February 23, 2018

**RE: Boulders Phase 3
Engineers Certification for Release of Financial Guarantee
Grading and Drainage Plan Stamp Date: 1/28/14
Certification Date: 2/14/18
Hydrology File: B10D001D**

Based on the Engineers Certification received on 2/14/18, this project cannot be considered for Release of Financial Guarantee by Hydrology until the following are corrected:

DRAWN BY
DY
DATE
2-12-14
DRAWING
GRADING-PH 3
SHEET #
1
JOB #
2011005

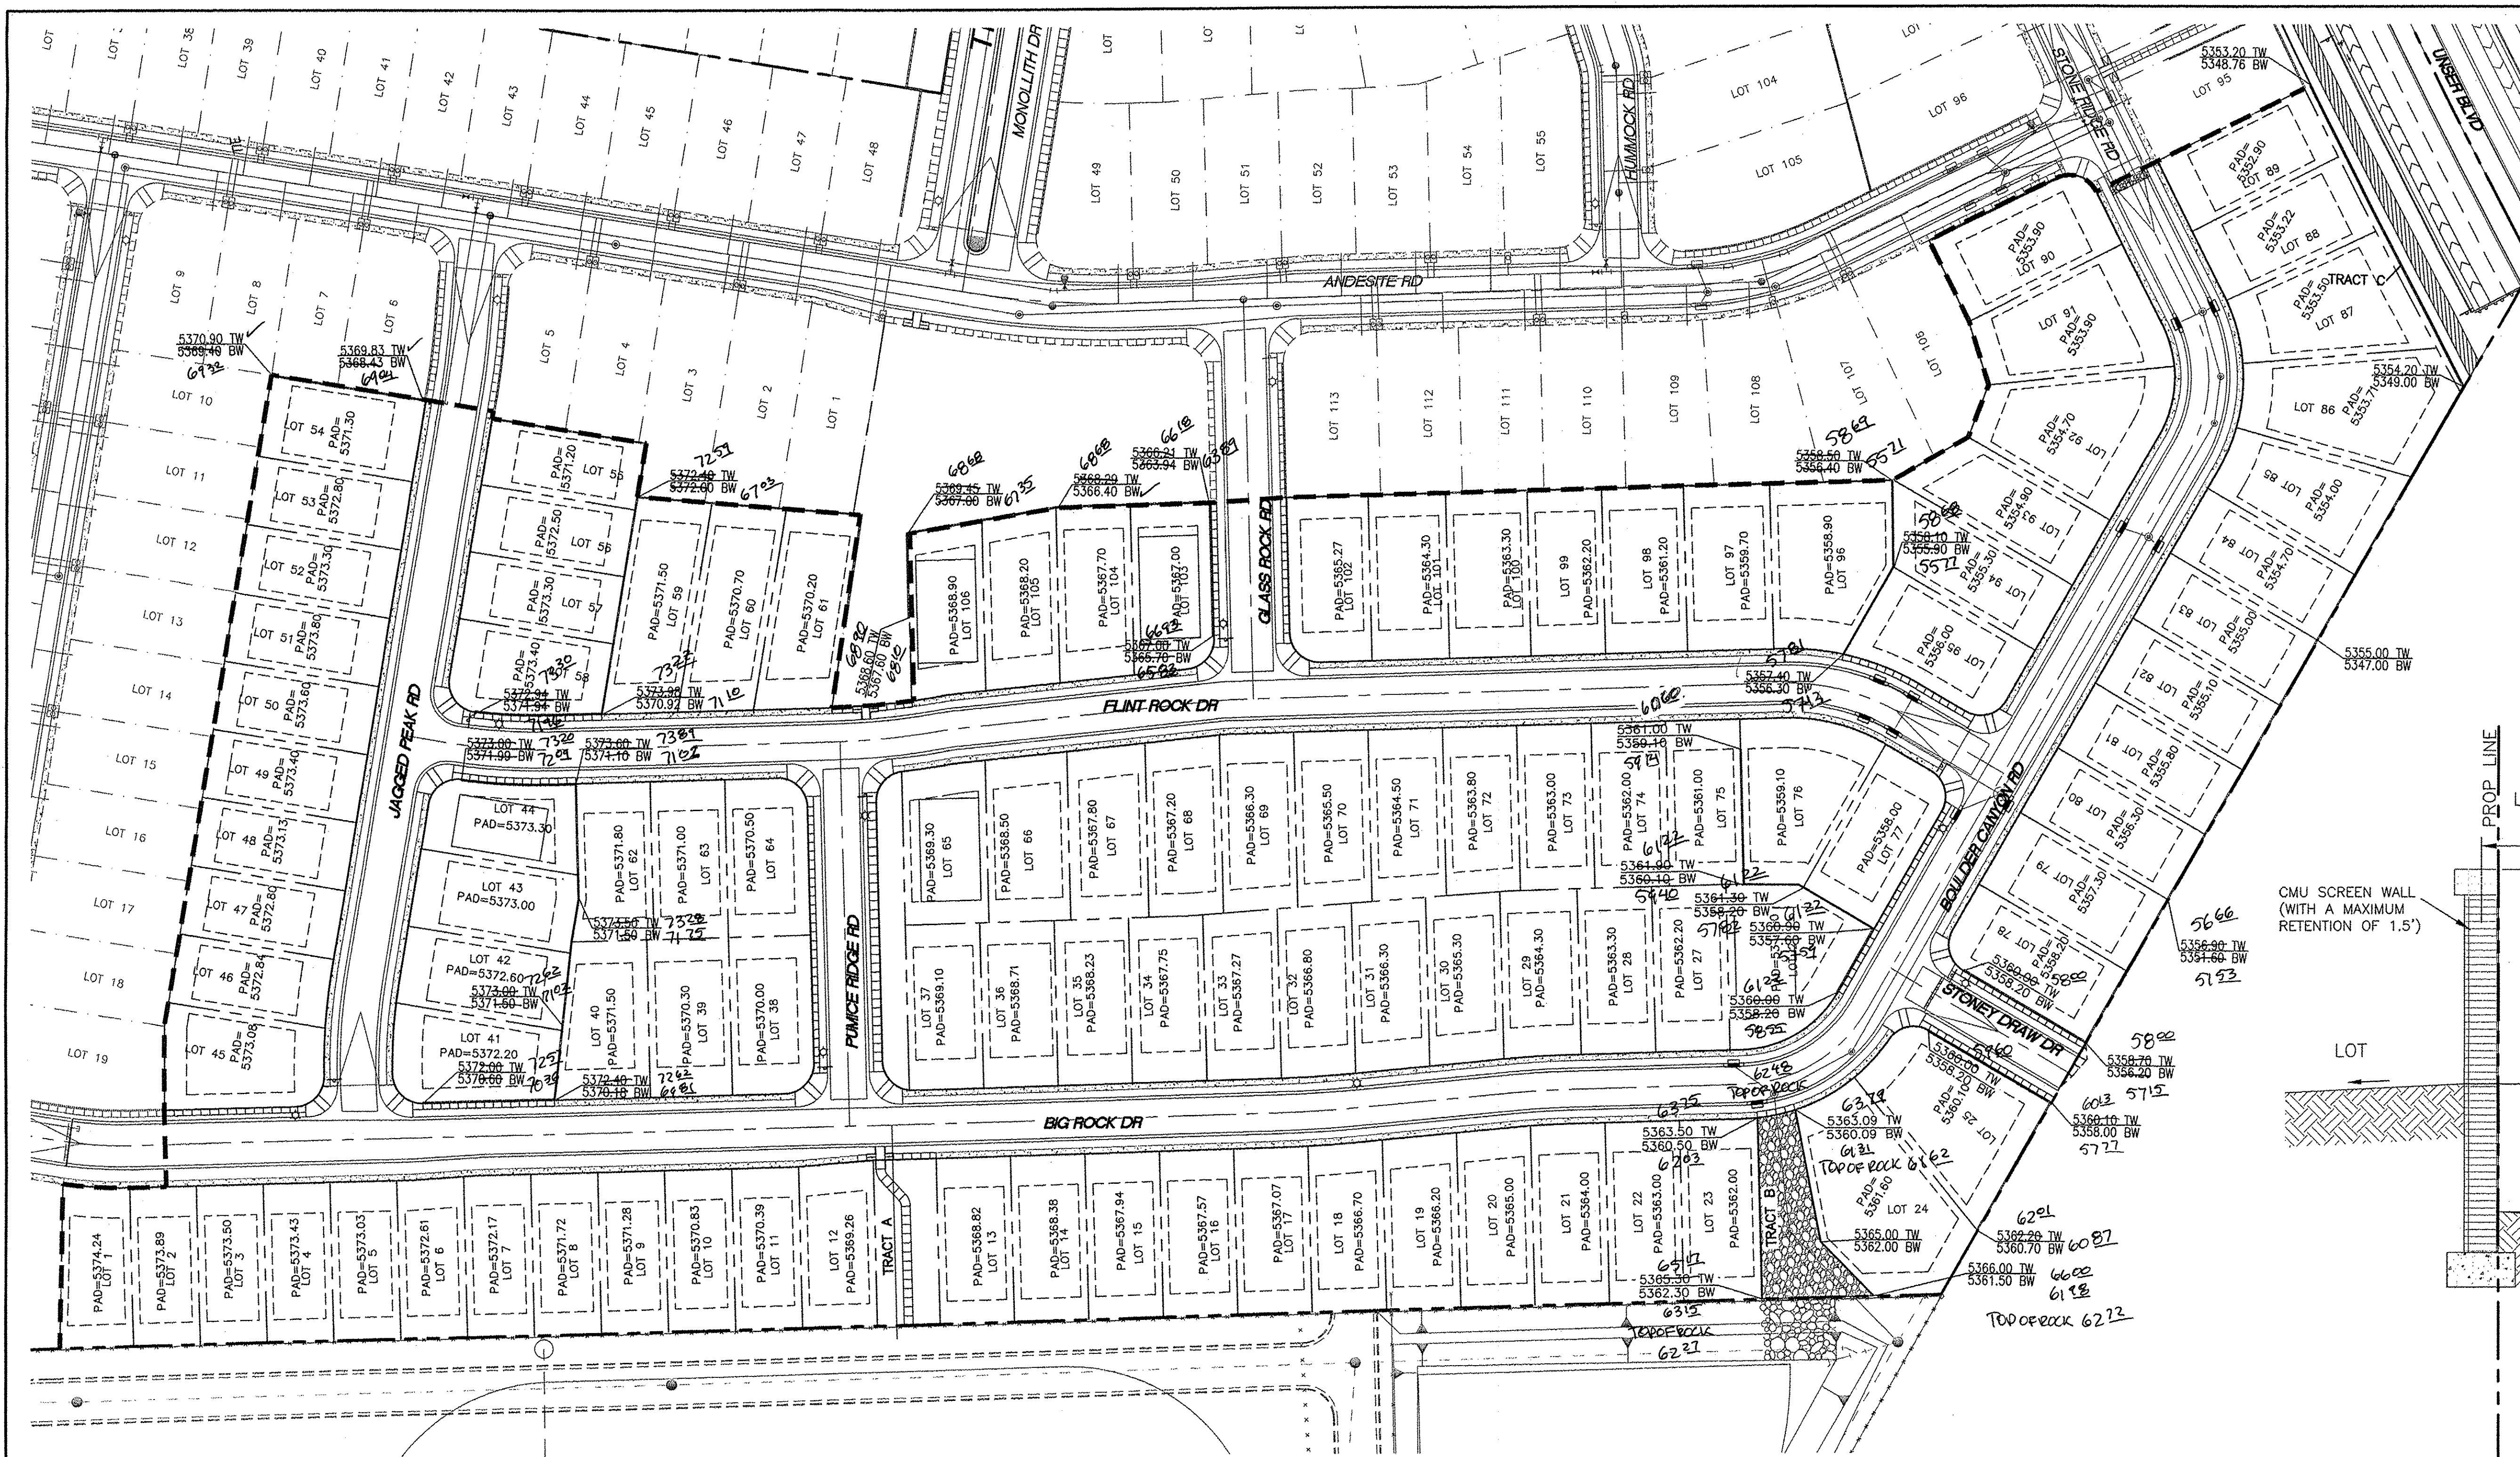
1. The entire Grading Plan needs to be as-built, certified, and complete for a complete release of financial guarantee. This includes Sheet 3 of the approved Grading Plan (Tract 6A Grading and Drainage Plan) and Unser. If the intent is to shift the pond improvements to the Unser SIA and not construct them at this time, then only a reduction of financial guarantee (exclusive of the pond and Unser improvements) can be considered. A cover letter or statement on the Certification, explaining such circumstances and signed by the engineer, would be helpful in this case.

2. The certification states that you inspected the site on 3/3/13, 1 year before the grading for the site was even approved. A recent site visit is needed to certify the as-built condition of the subdivision.

|  VINCENT P. CARRICA P.E. #16212 | THE BOULDERS PHASE 3 | DRAWN BY DY |

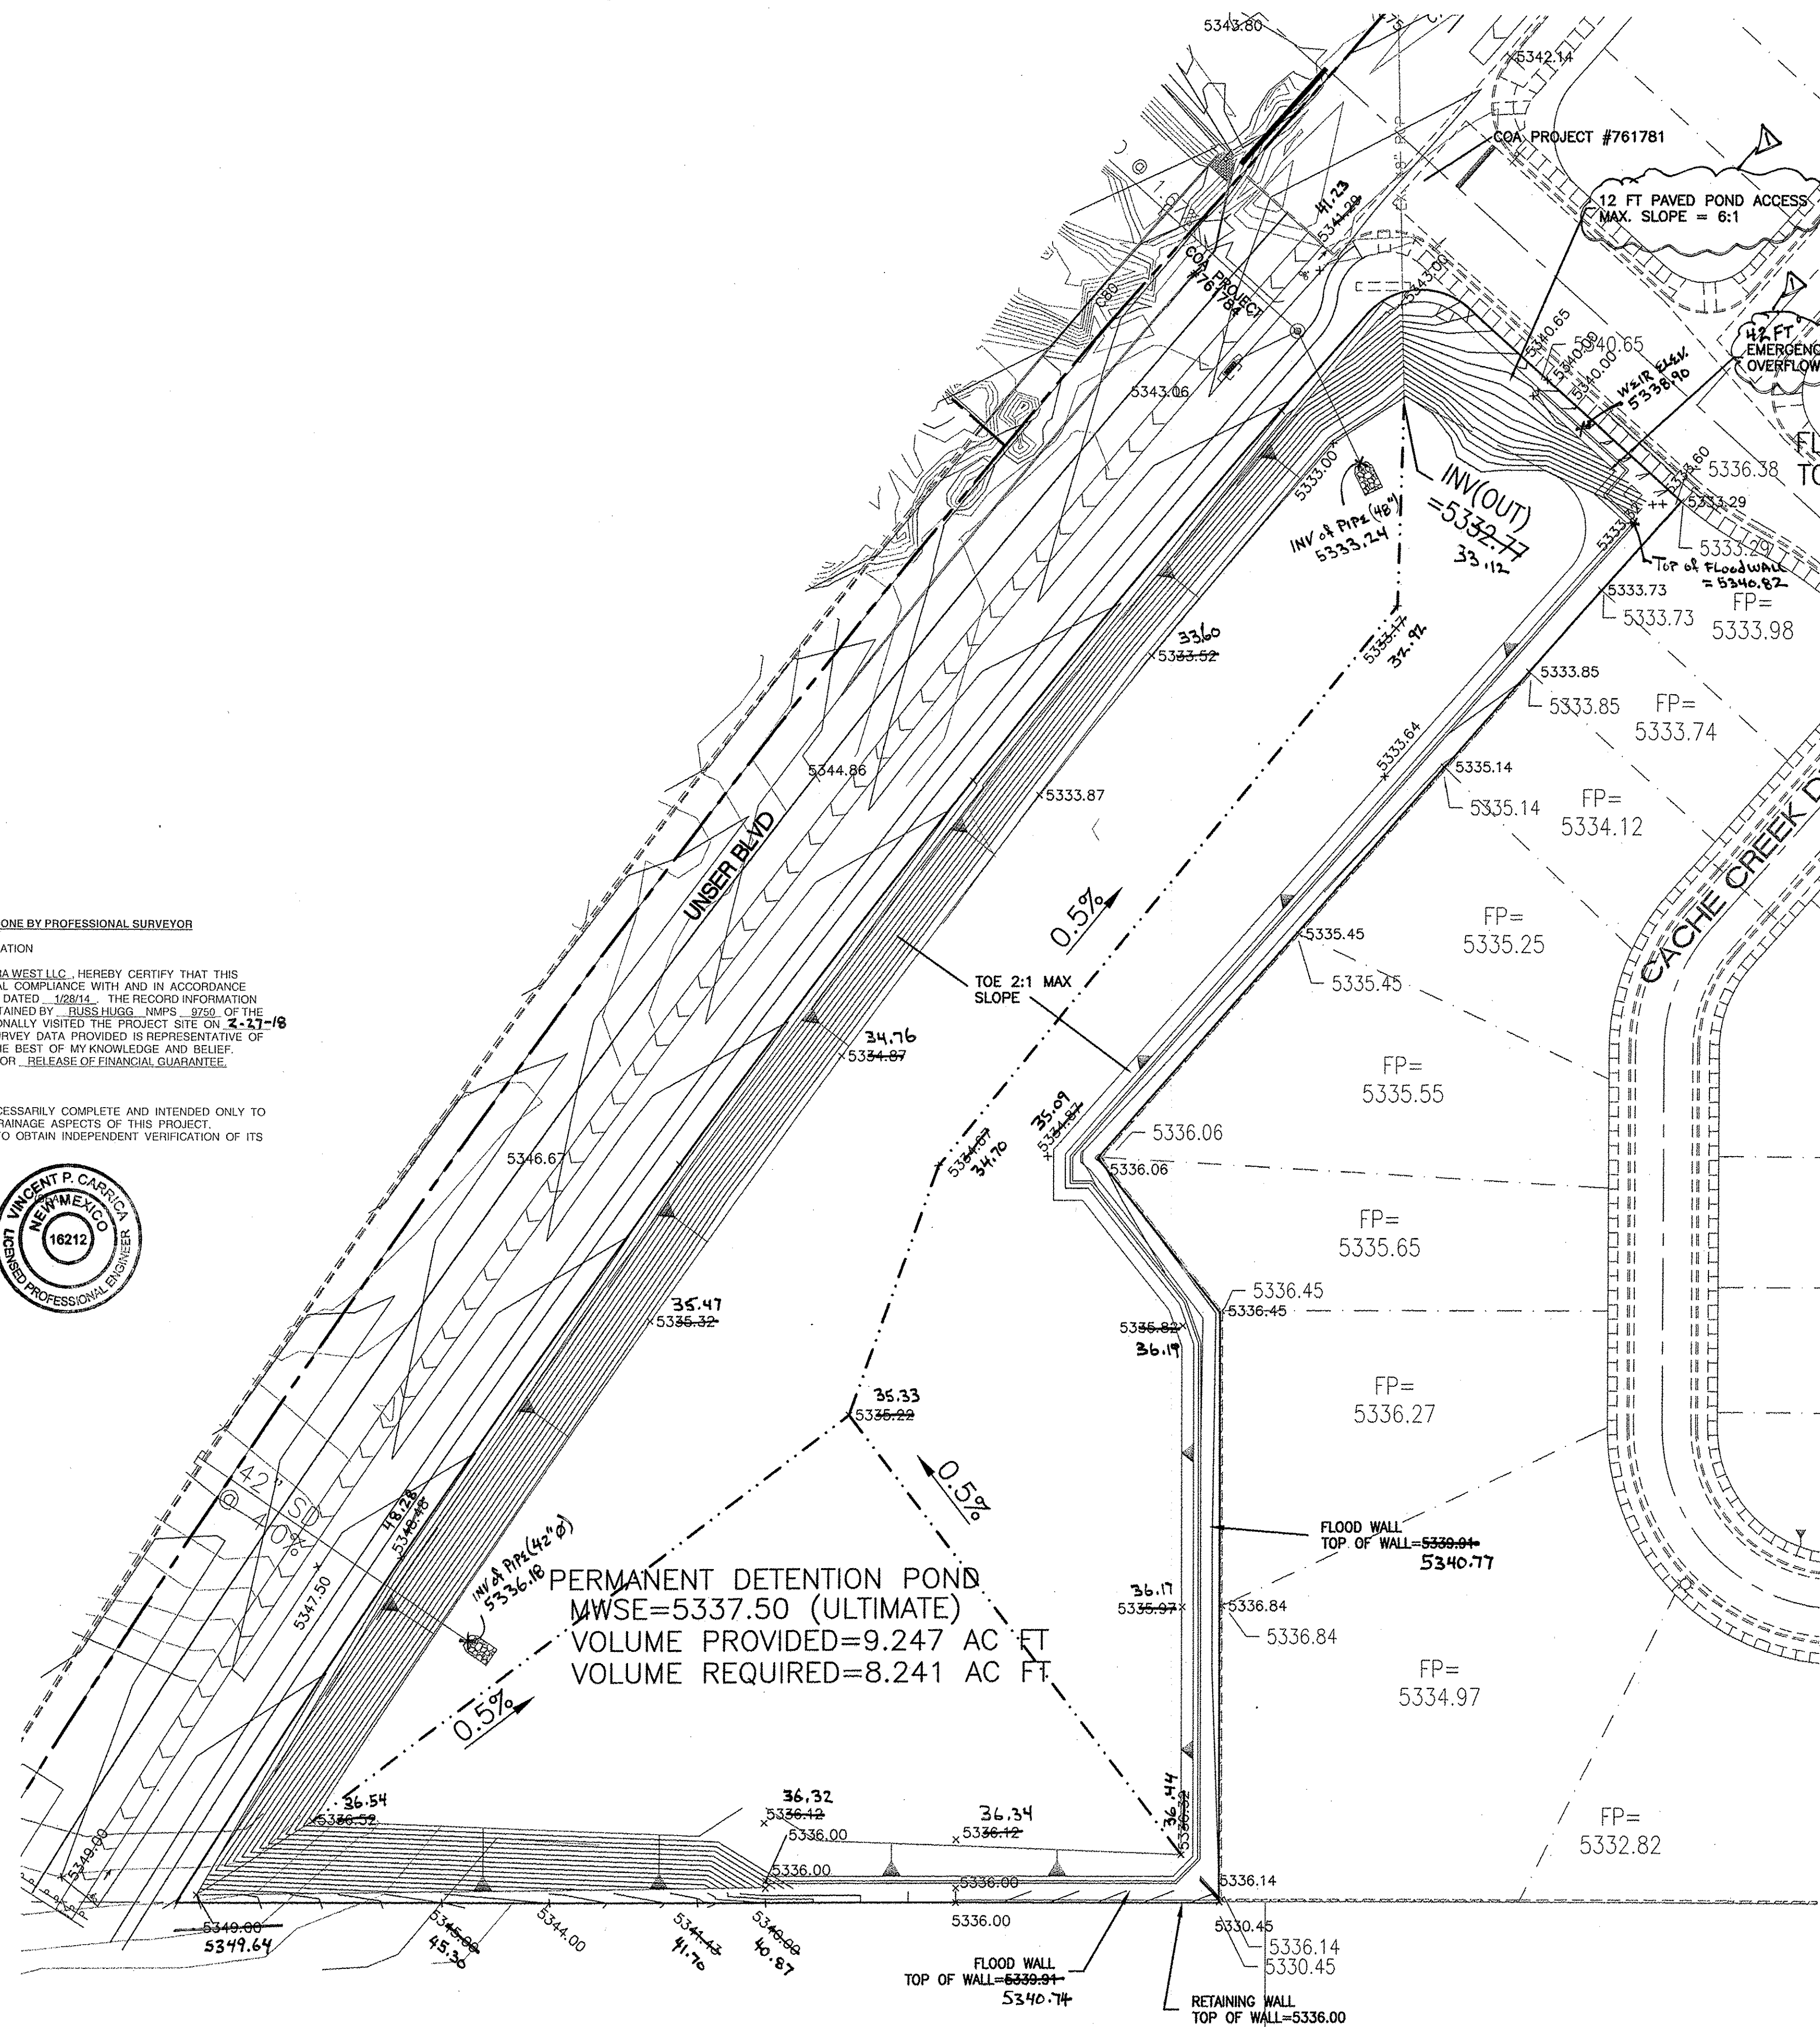
3. Lots 27-37 and 65-75 are fully constructed; no temporary depressions in the rear of the lots remain. This note should not be included in the certification (Sheet 2: Retaining Walls).

4. Revision notes 1 and 2 (Sheet 2: Retaining Walls) appear to have been completed and should be certified as complete. If this work is still incomplete, then financial guarantees cannot yet be released (or reduced).
